Sea Link Energy Cable

**Natural England's additional comments regarding Landscape and Visual Impacts
including reference to documents included in REP1- 120 regarding acid grassland
proposals.**

Planning Inspectorate Reference EN020026

9th December 2025

SUFFOLK PHASE 1 LAND PARCELS

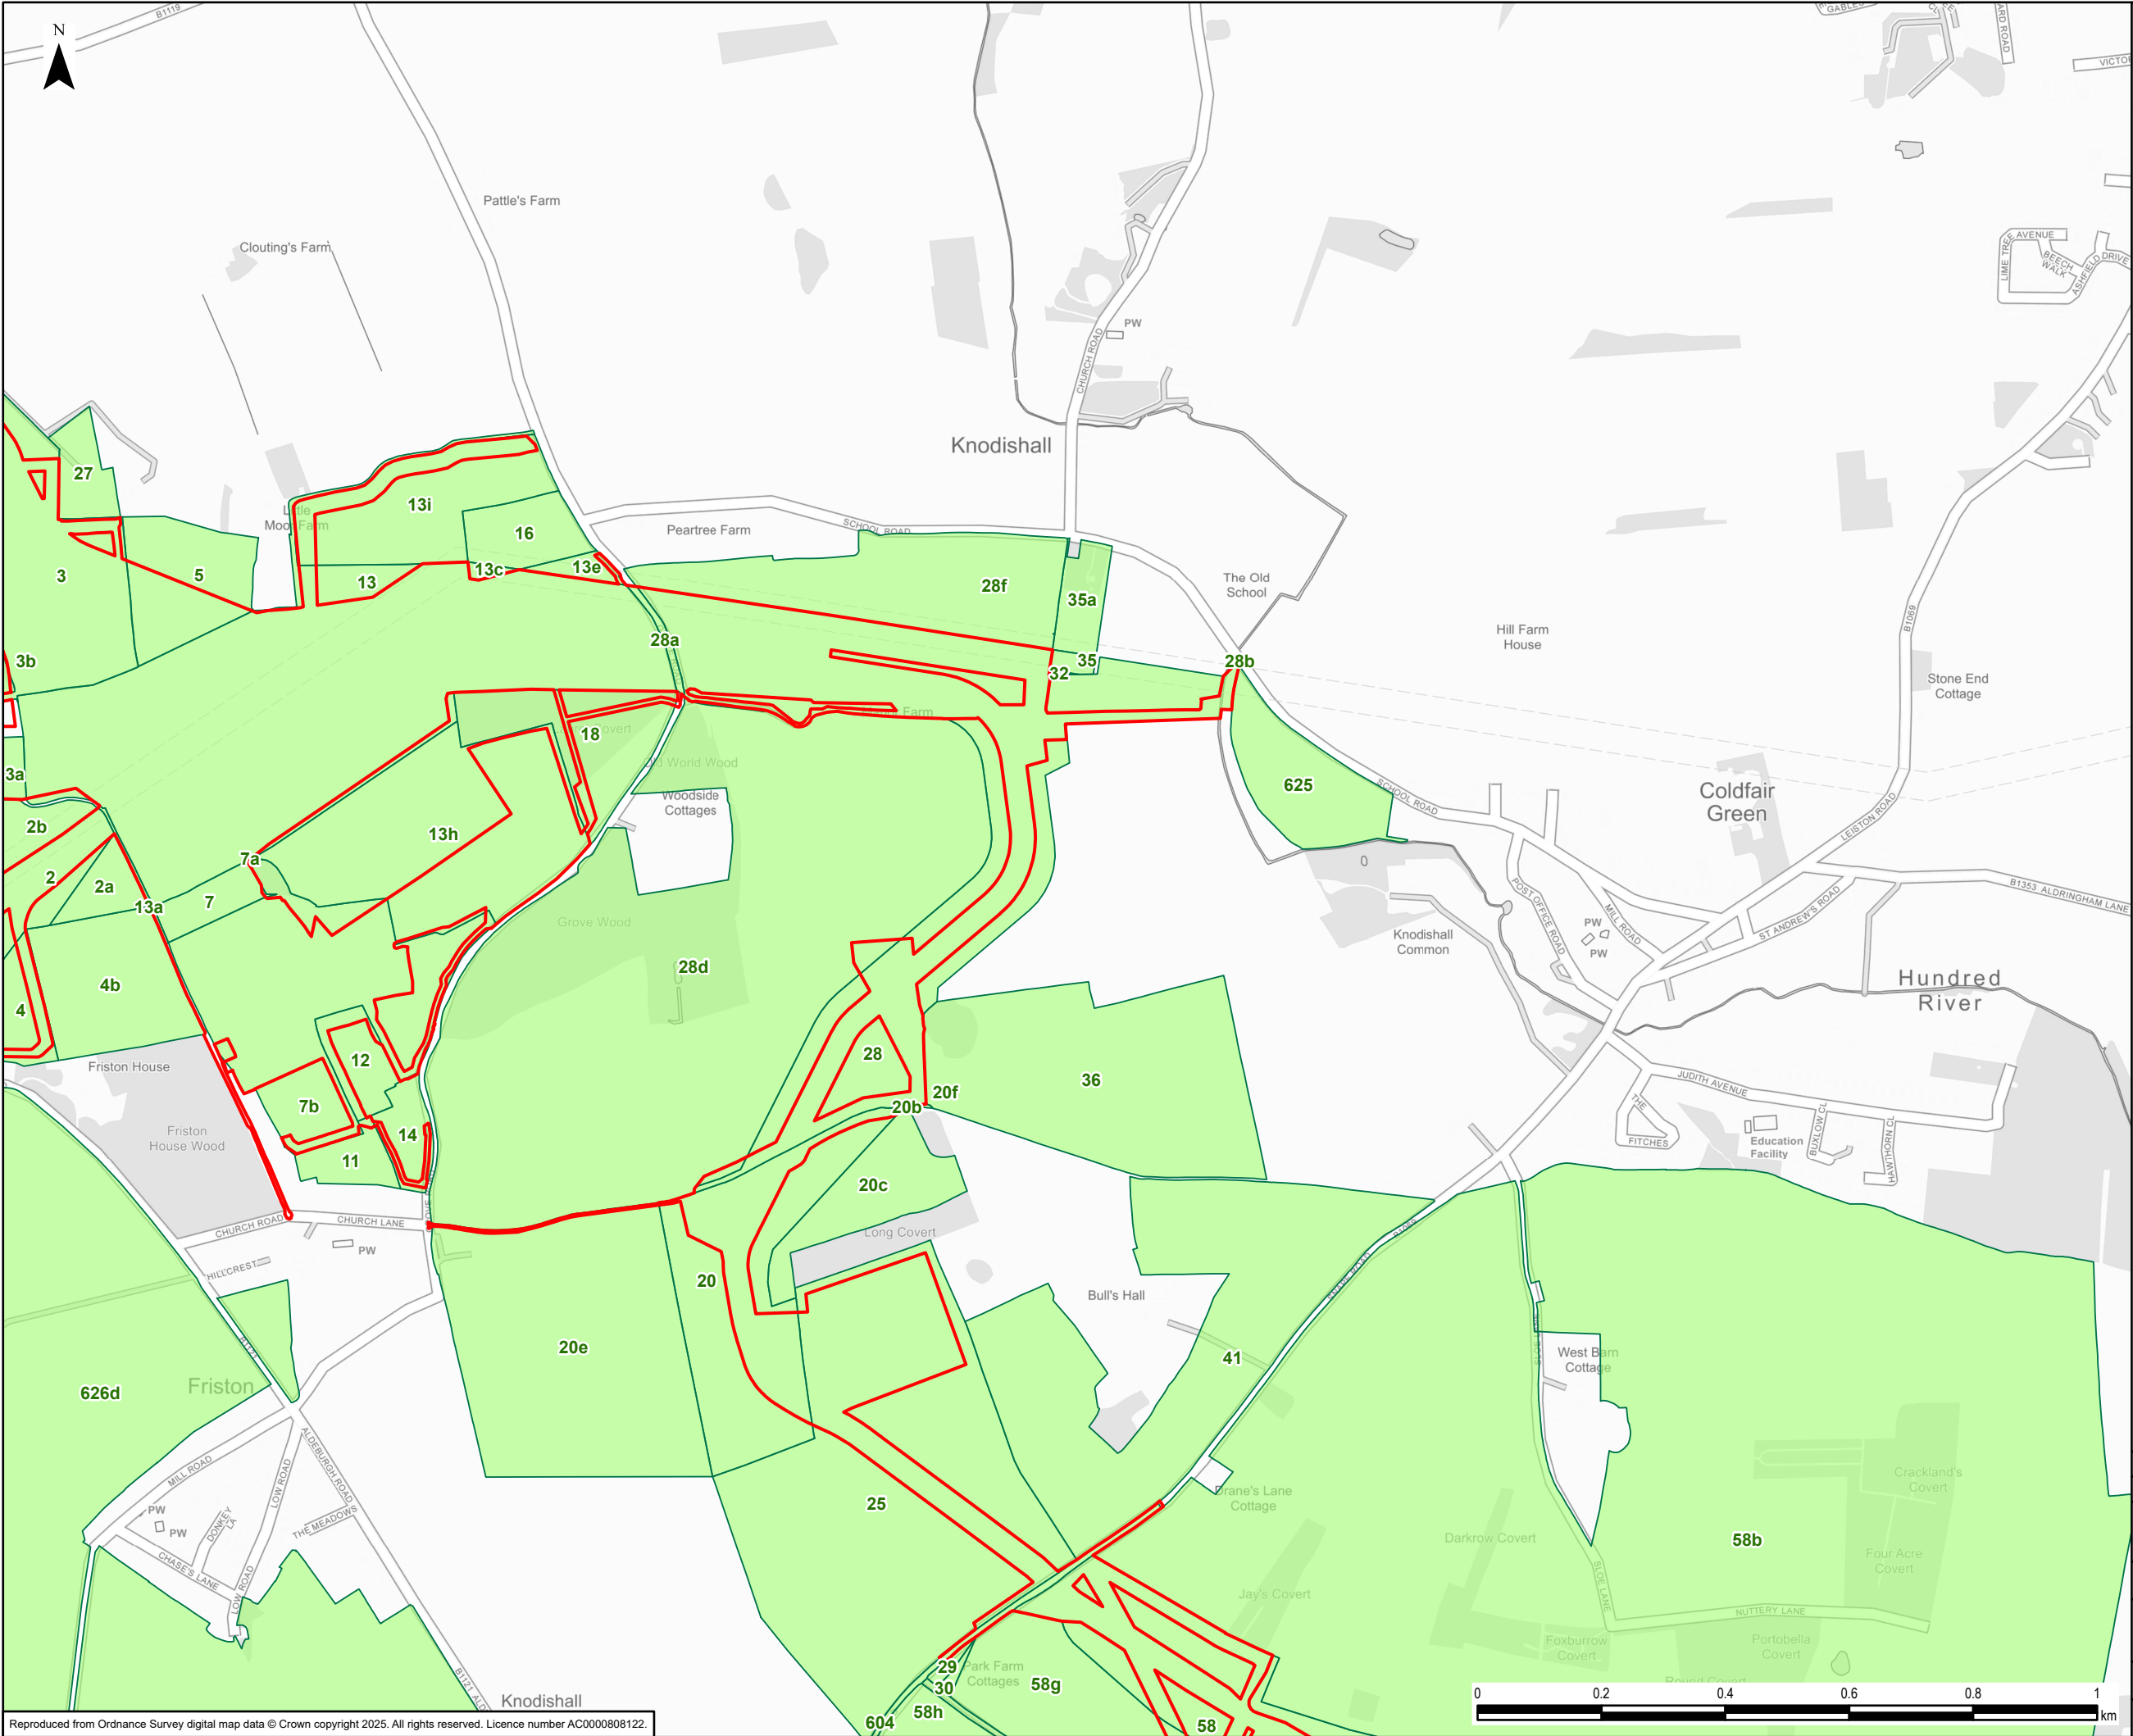
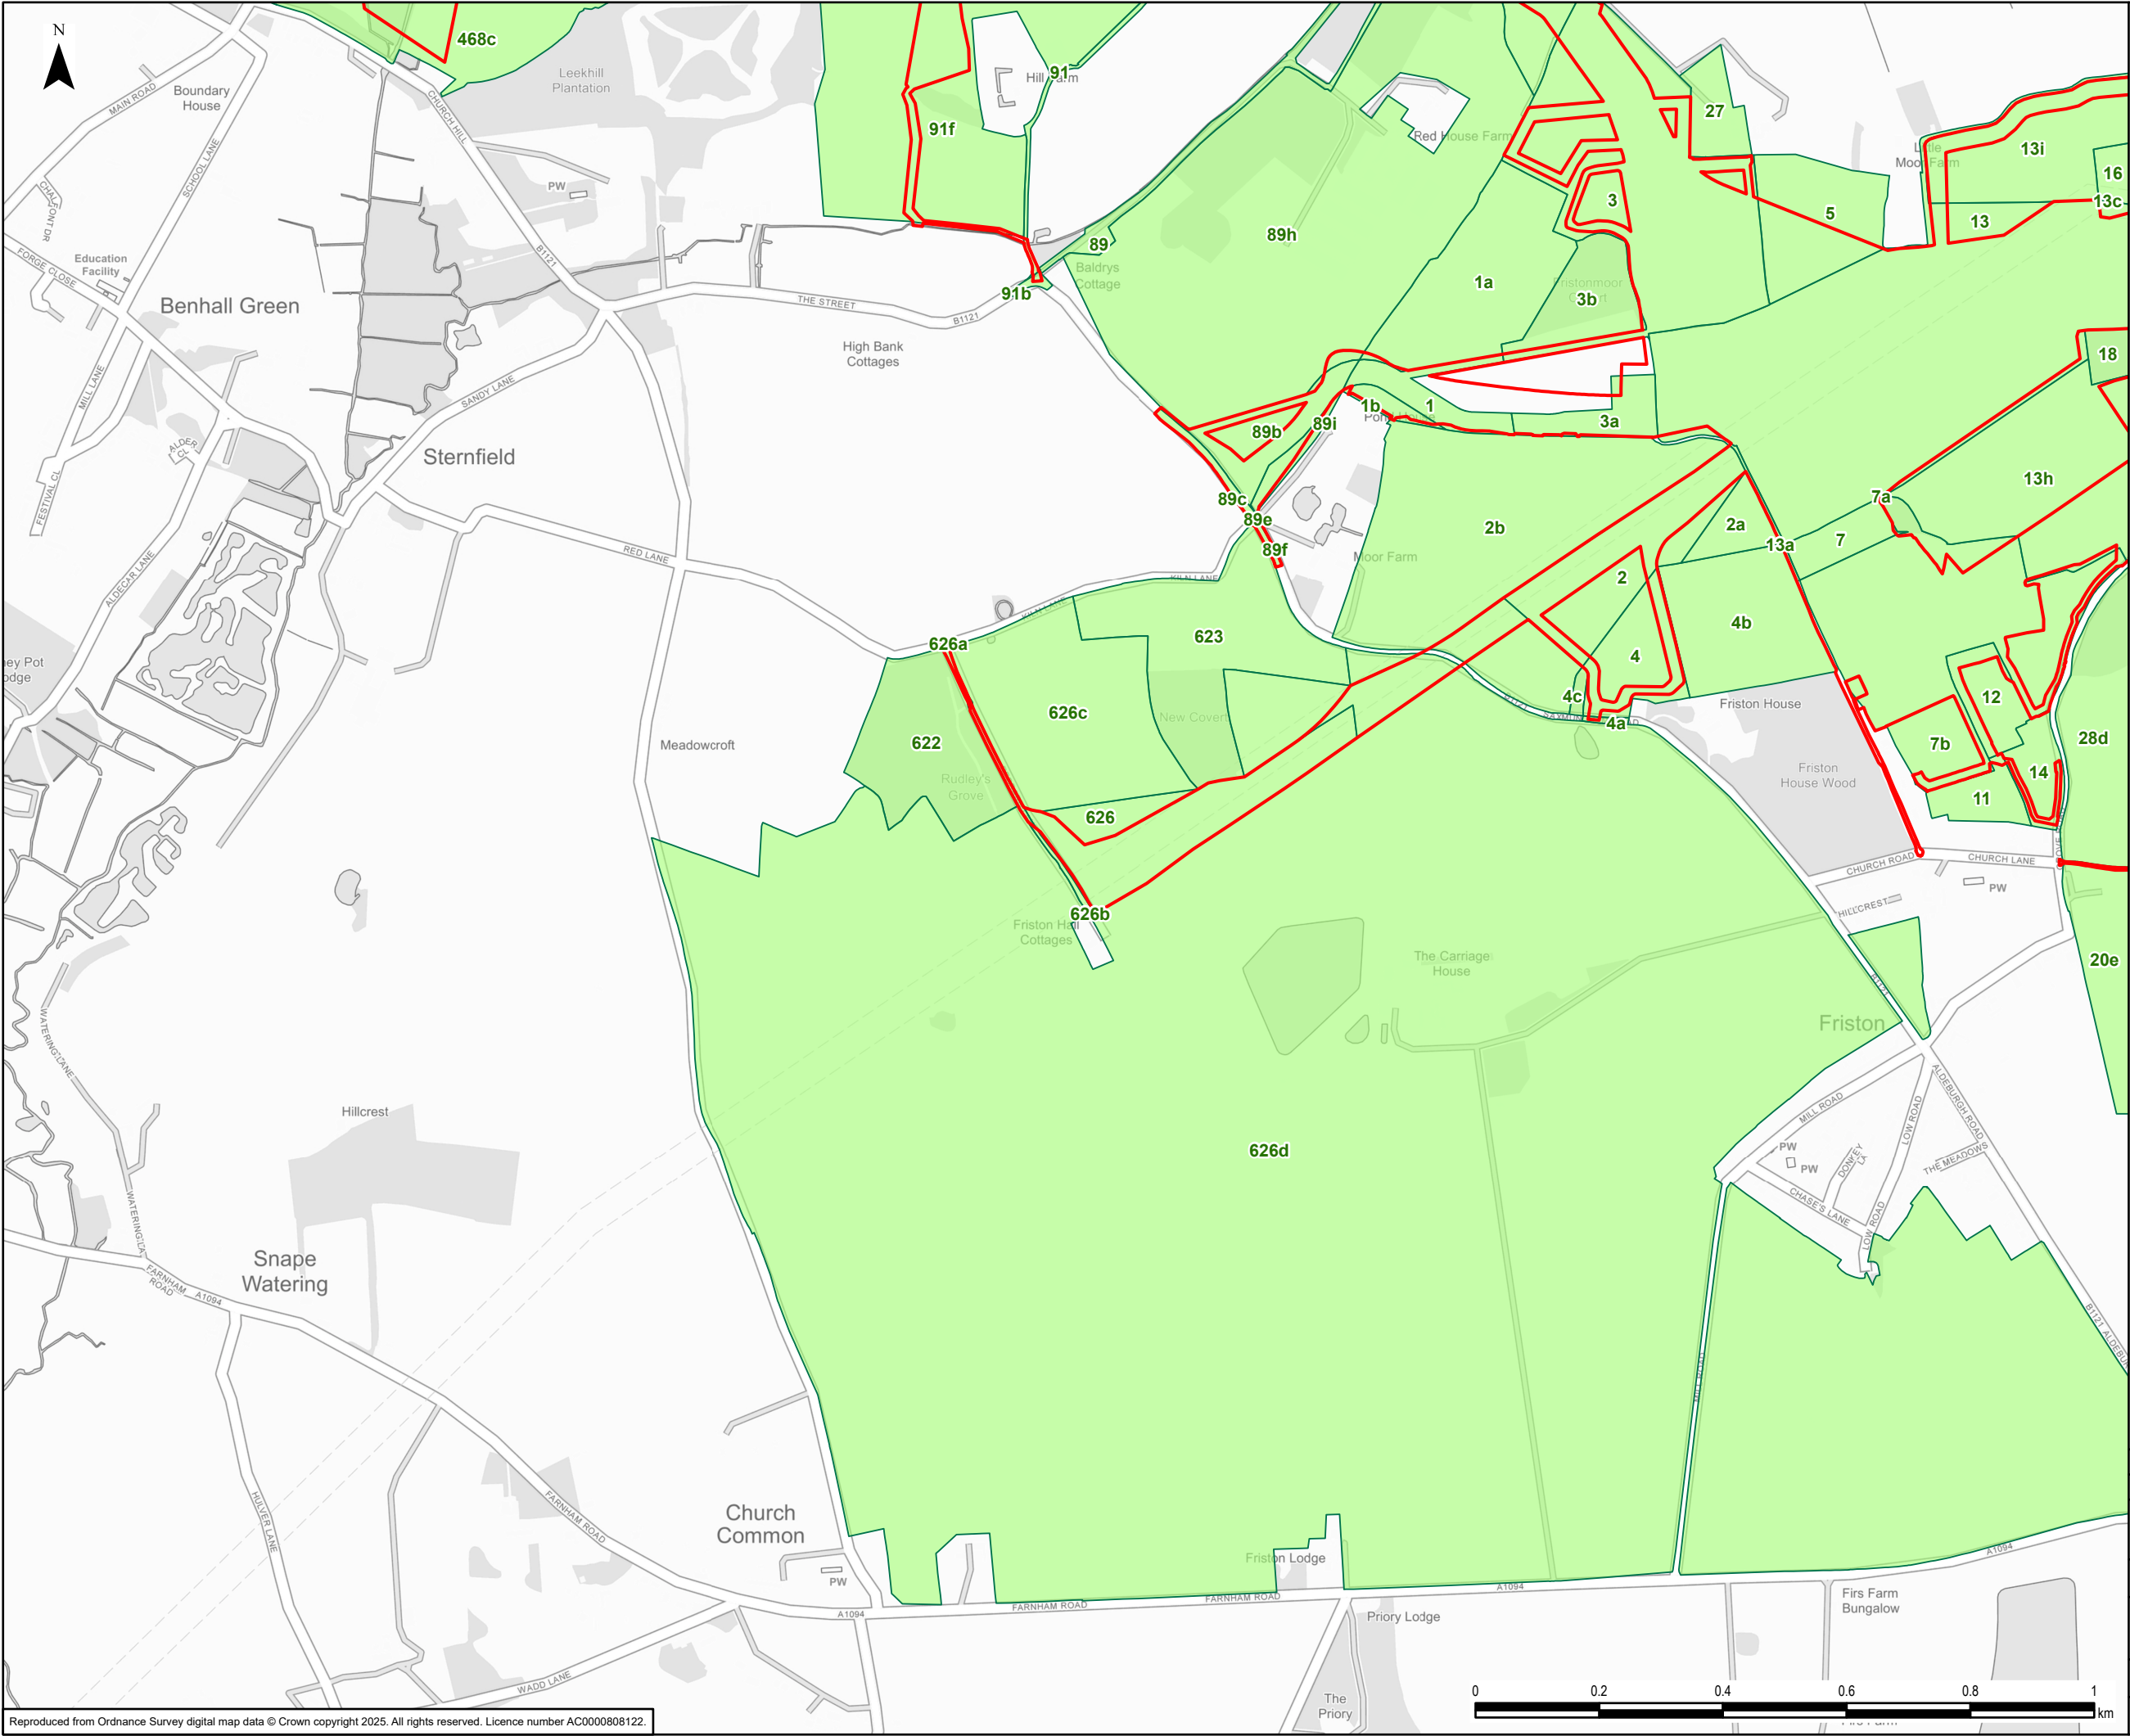
3	<p><u>Baseline botanical information</u></p> <p>Natural England note that paragraph 1.4.31 states that the “mitigation area” comprises “3.75 ha of semi-improved acid grassland” which is “species poor”.</p> <p>It is unclear what the quality of individual parcels are and whether they are semi-improved acid grassland or priority habitat. More botanical species information is required on all areas of acid grassland highlighted in the Phase I survey.</p> <p>It is unclear what time of year the botanical survey was conducted. It is crucial that acid grassland is surveyed in late spring/early summer to pick up the more uncommon species in this habitat. By mid to late summer these will no longer be visible.</p>	<p>Natural England advise that the Applicant should provide details on the condition of the acid grassland being temporarily lost, and details on when the botanical survey was undertaken.</p>
